Application Ref.: F/5/20/PL

Proposal: Reconfiguration of Ford Market, including revised market access, hardstanding for replacement vehicular parking and associated infrastructure, landscape, ancillary and site preparation works.

Location: Ford Airfield Market Ford BN18 0FL

I refer to the above planning application and the recent submission of a Waste Infrastructure Statement prepared by Barton Willmore on behalf of the applicant and my letter of objection dated 27th March 2020. I should be grateful if you would take account of the additional representation below.

Drawing Title
PROPOSED SITE PLAN

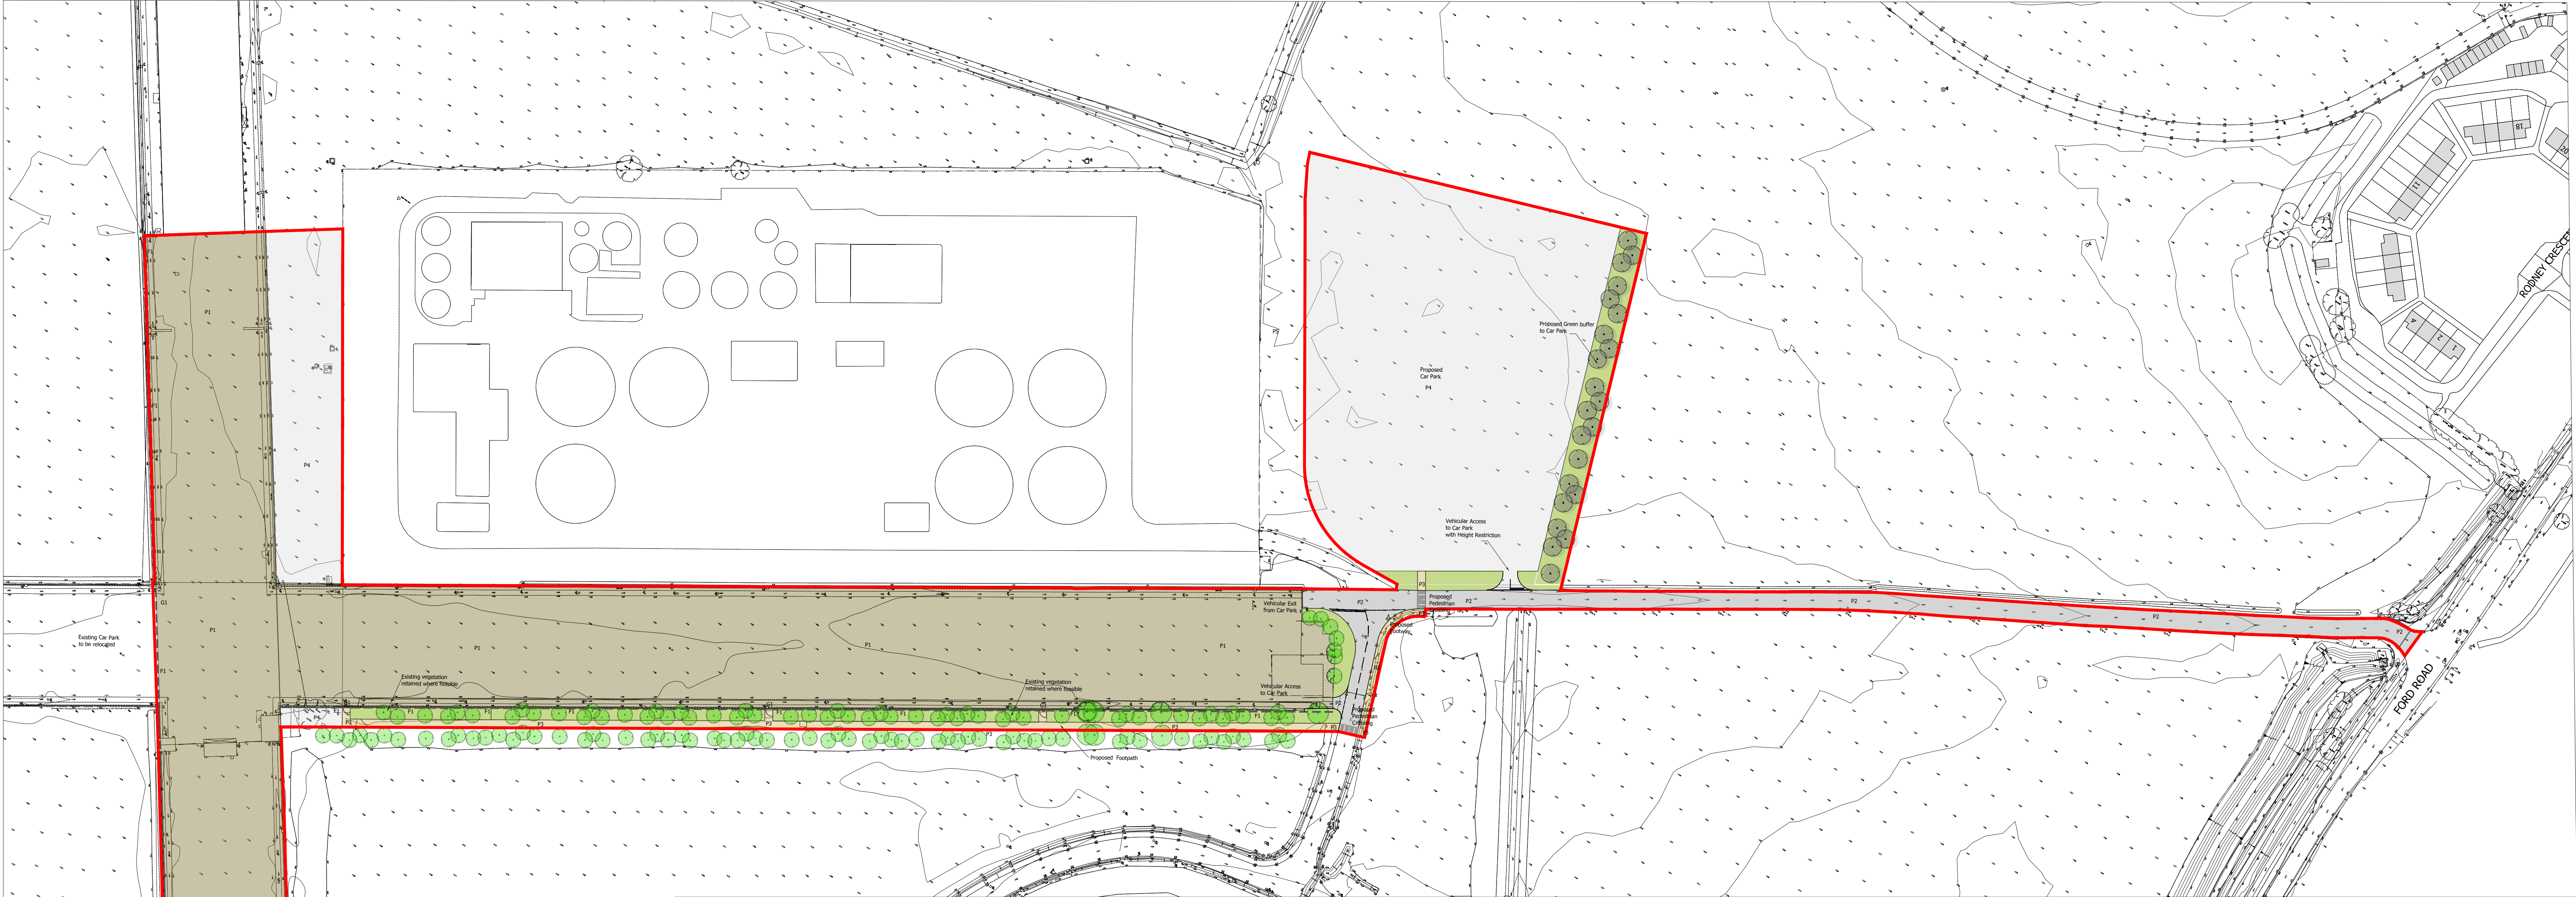
It is therefore disappointing that despite having previously flagged a serious concern in relation to the layout and design of the new access arrangements, that no safety audit, further detail or comfort has been forthcoming.

The new access arrangements will create a new access point and two new pedestrian crossings. It is clear that this arrangement will create an unacceptable conflict between the vehicles visiting Viridor's facility and the pedestrians crossing the roads from the overflow car park to access the rest of the market.
